CITY OF ALBUQUERQUE

March 24, 2015

**Re: Heritage Marketplace
Engineer's Stamp Date 3-9-15 (H09D024)**

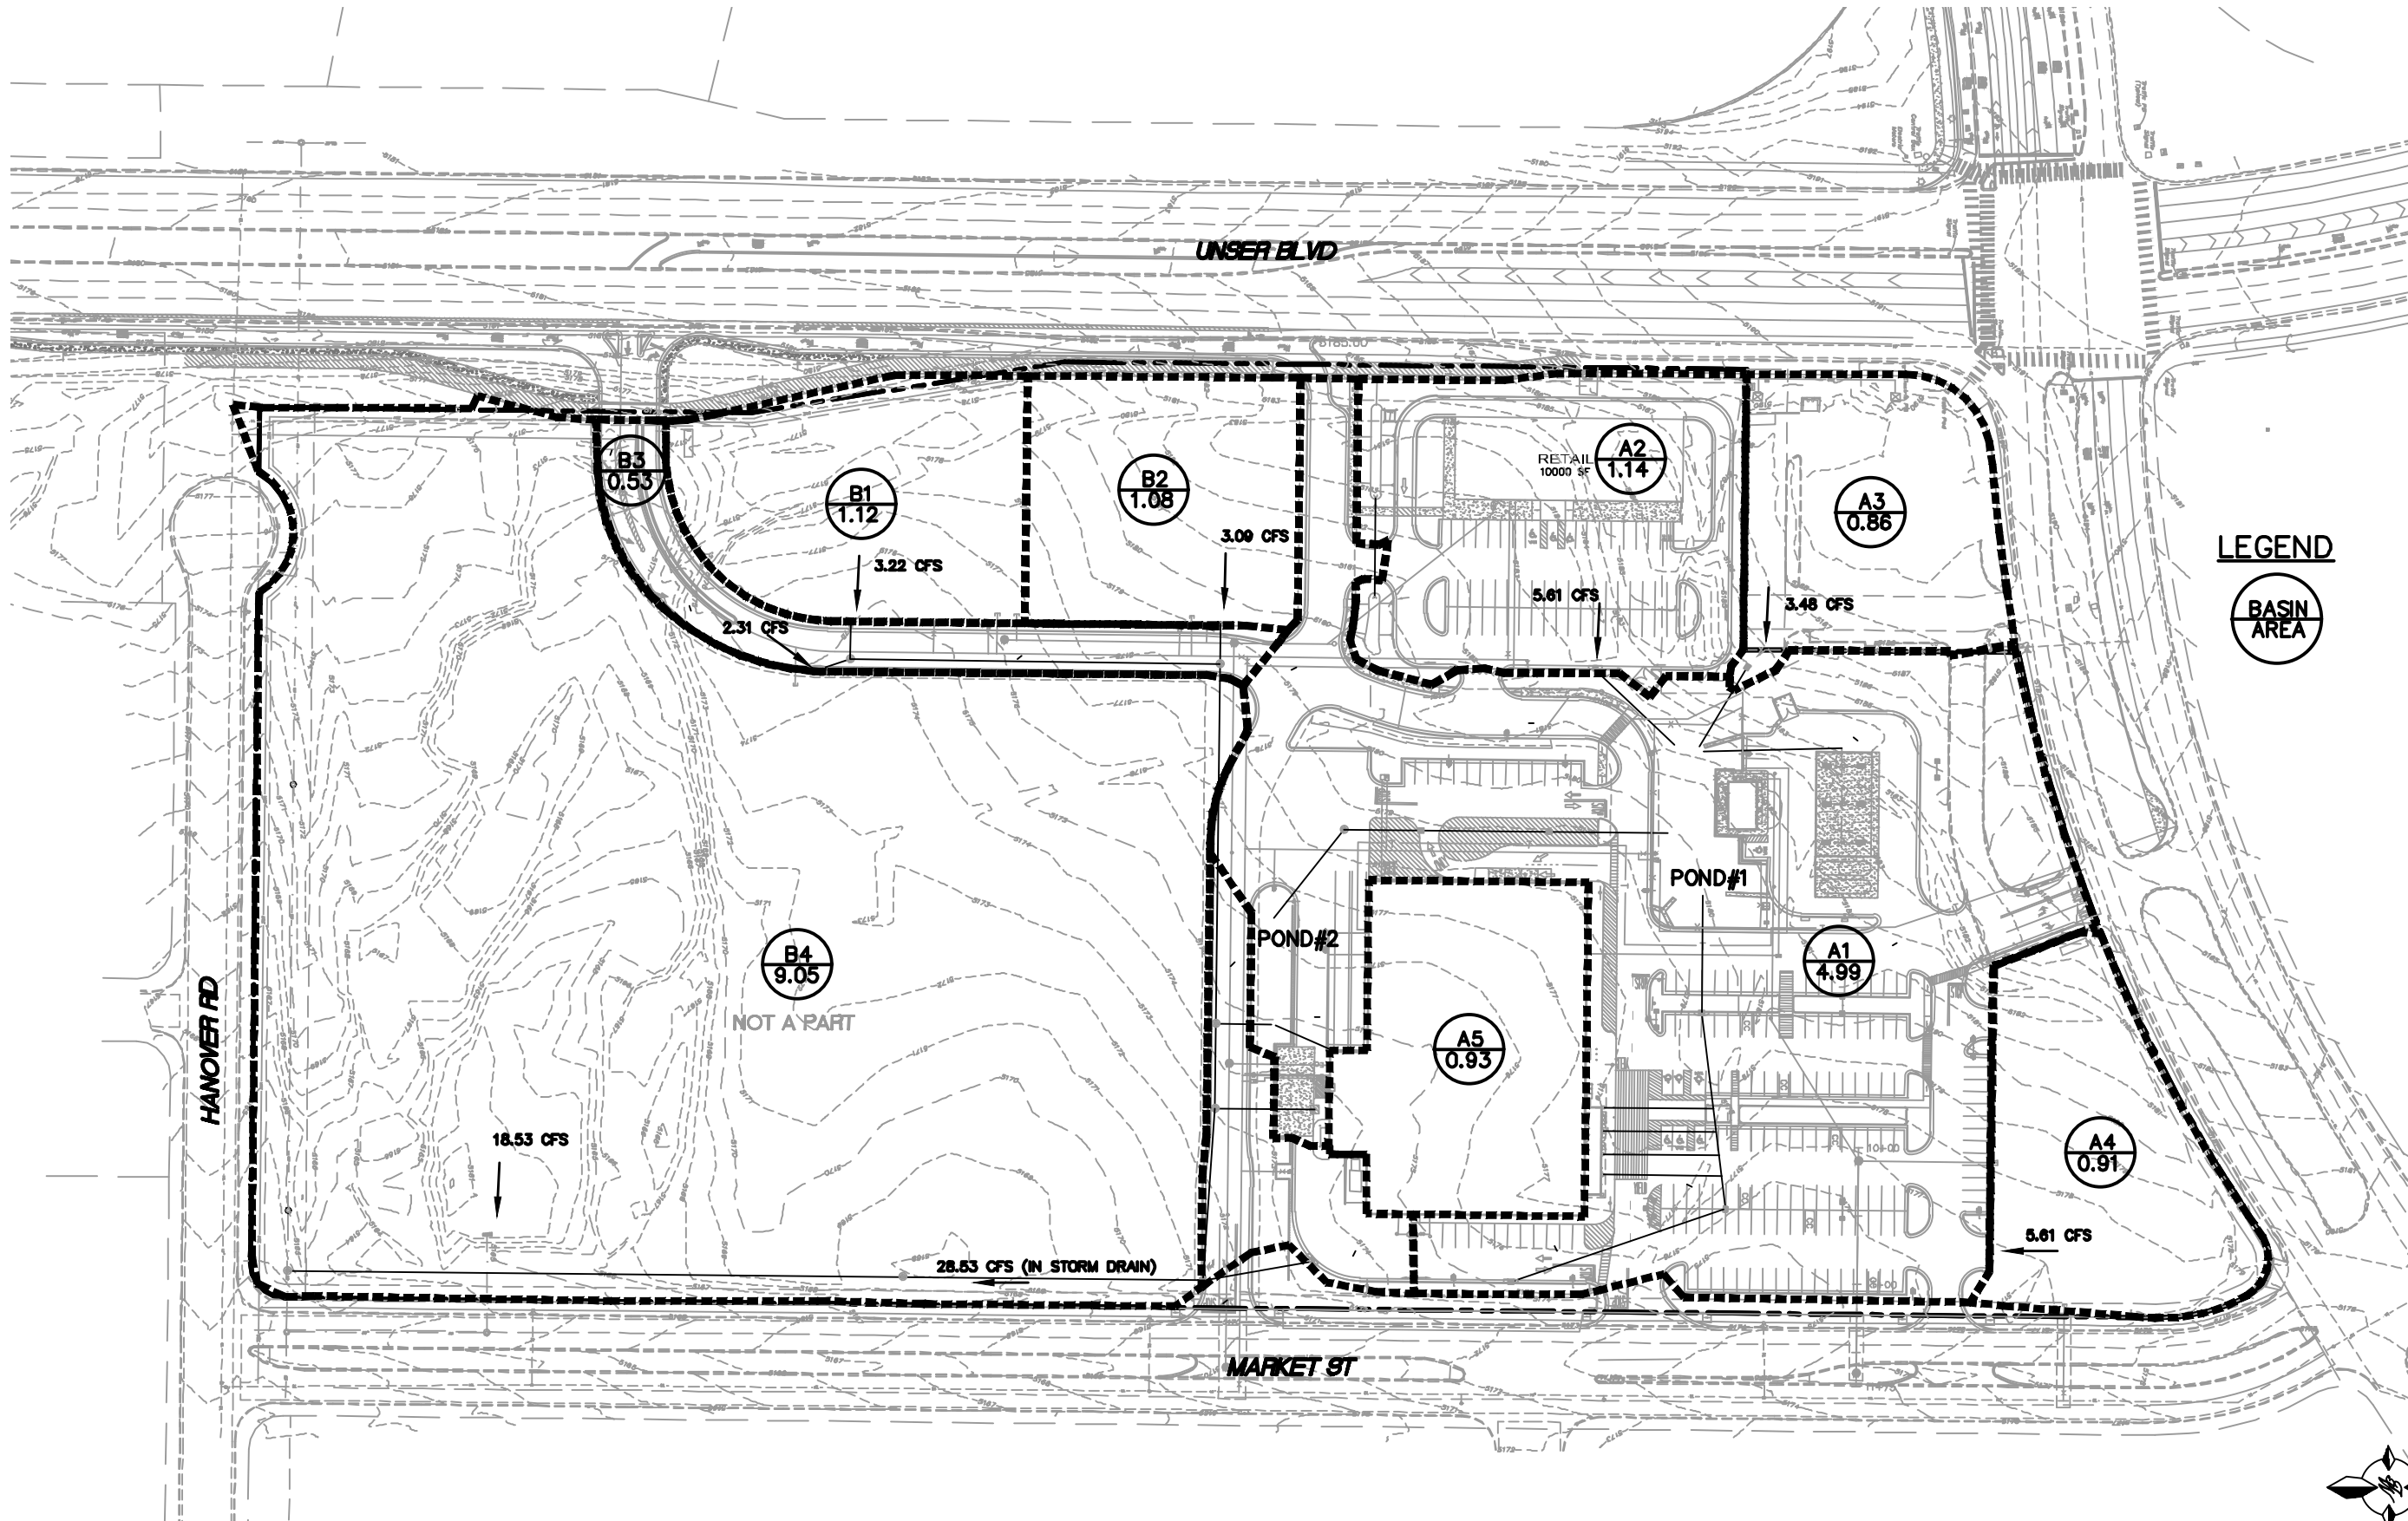
4. The narrative for pad site C is for a different location.

DRAWN	pm
CHECKED	JH
DATE	2-5-15
SCALE	1"=40'
SHEET NO.	2014038
SHEET	C-6
OF	SHEETS

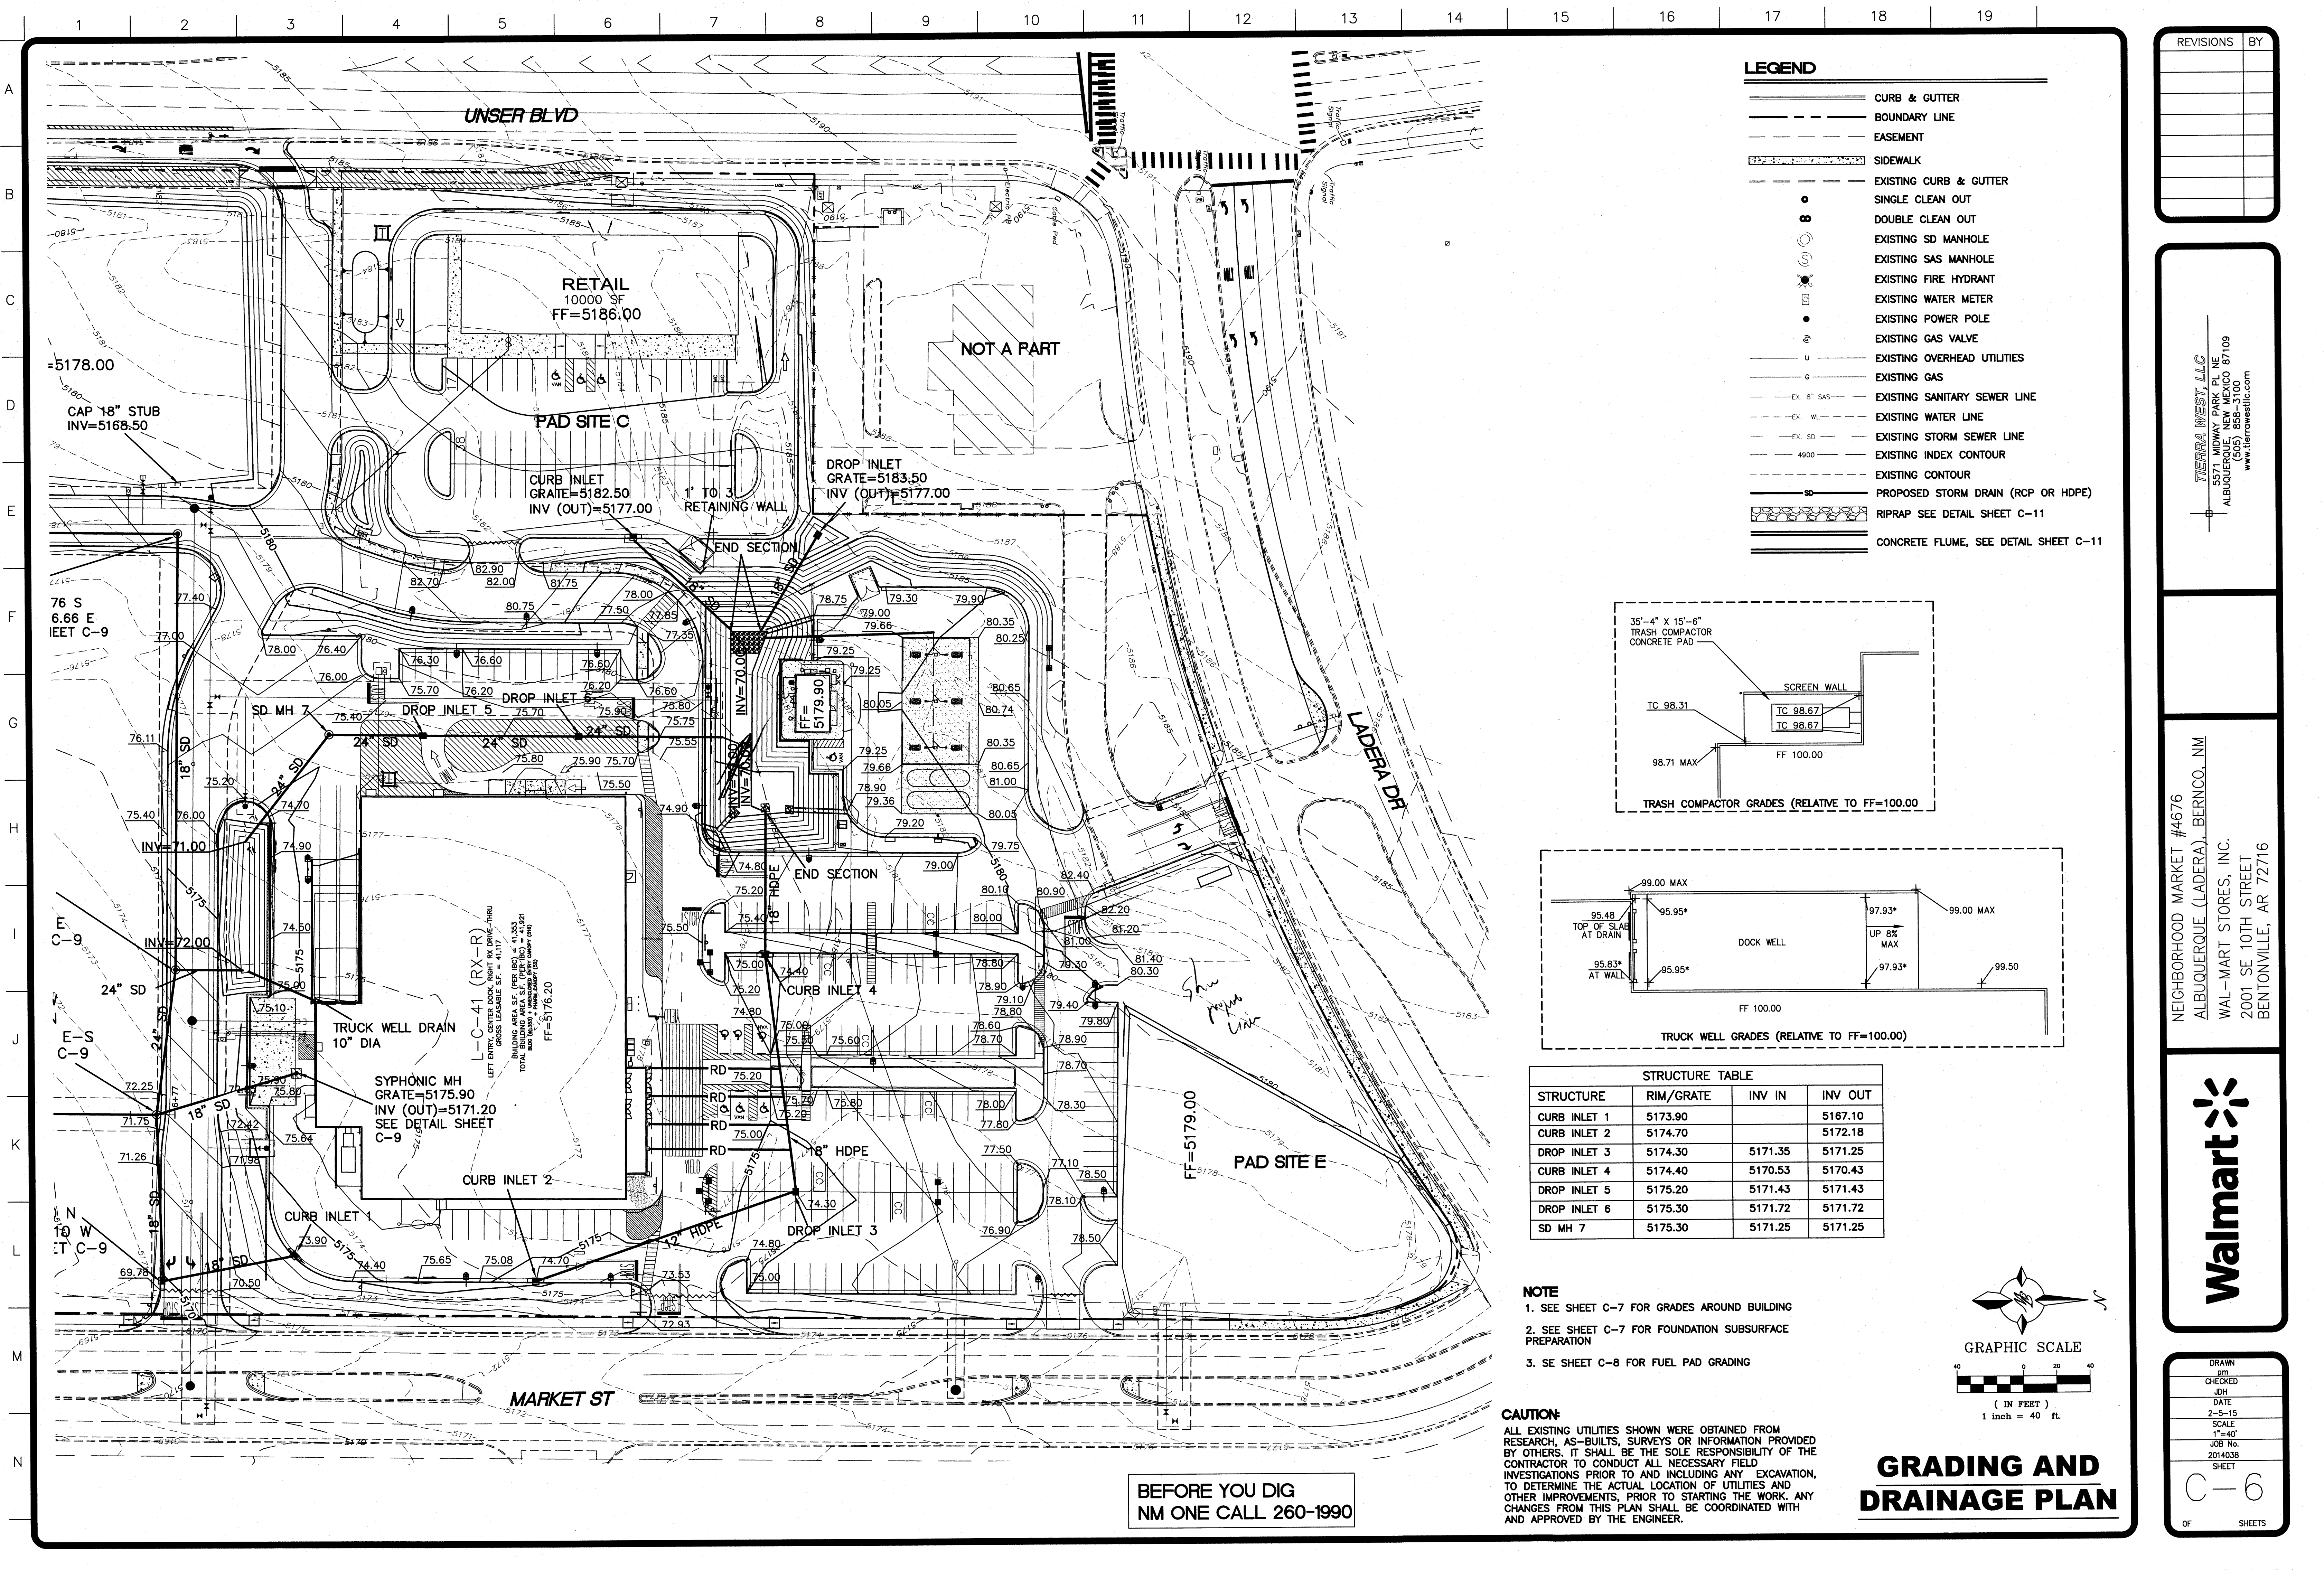
1. It appears the sump near Pad Site A and the pad grade of Pad Site A is lowering the storm drain profile and making it difficult to drain Basin B3 into Pond 2 to capture the first flush. If the road was straight-graded and Pad Site A raised, this would create enough grade to raise the storm drain profile and drain Basin B3 into Pond 2.

2. The first flush runoff from the roof of the anchor store should be retained. The finished floor elevation is 76.2 and the pond bottom is at 71 (70 in first flush calcs), so it appears easy to capture this stormwater.
